From: Simon Davis
Sent: 23 April 2026 11:57
To: [Redacted]
Subject: P/42/26/NMA Land north of Sefter Road

You have included drawing 040269 Rev A.2 "GRP Trussed Apex Door Canopy" as a replacement to drawing 1308078 Rev A.3. However, the latter is not included in the plans list on condition 1 of P/49/21/RES. It is unclear therefore when or where that drawing was approved? Perhaps it was not originally a planning drawing (rather a construction drawing). Please advise.

GRP Trussed Apex Door Canopy

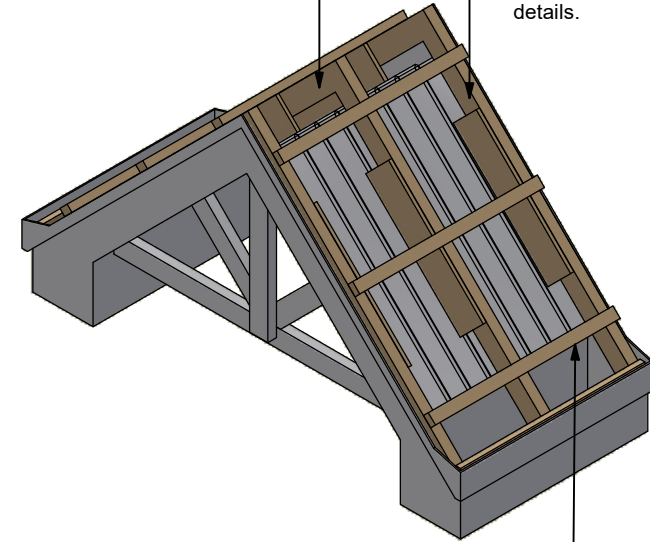
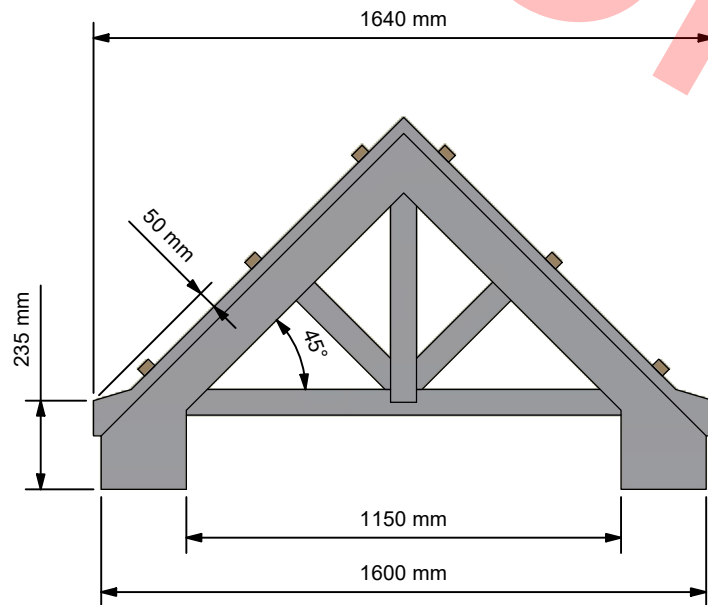
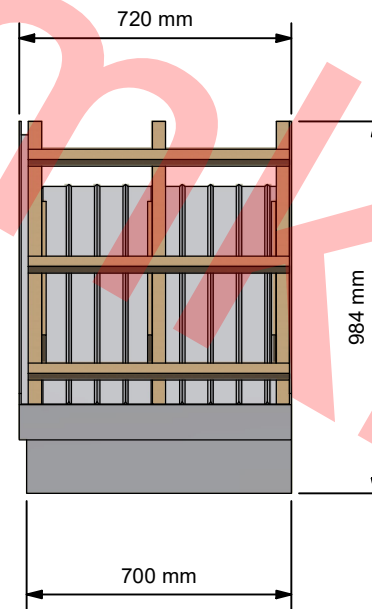
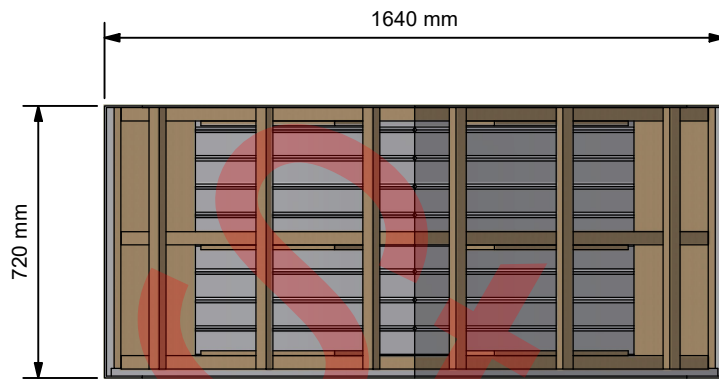
Can you also confirm (as it is not clear) what colour/type of tiles will be affixed to the new apex roof? Will they match with those on the main roof?
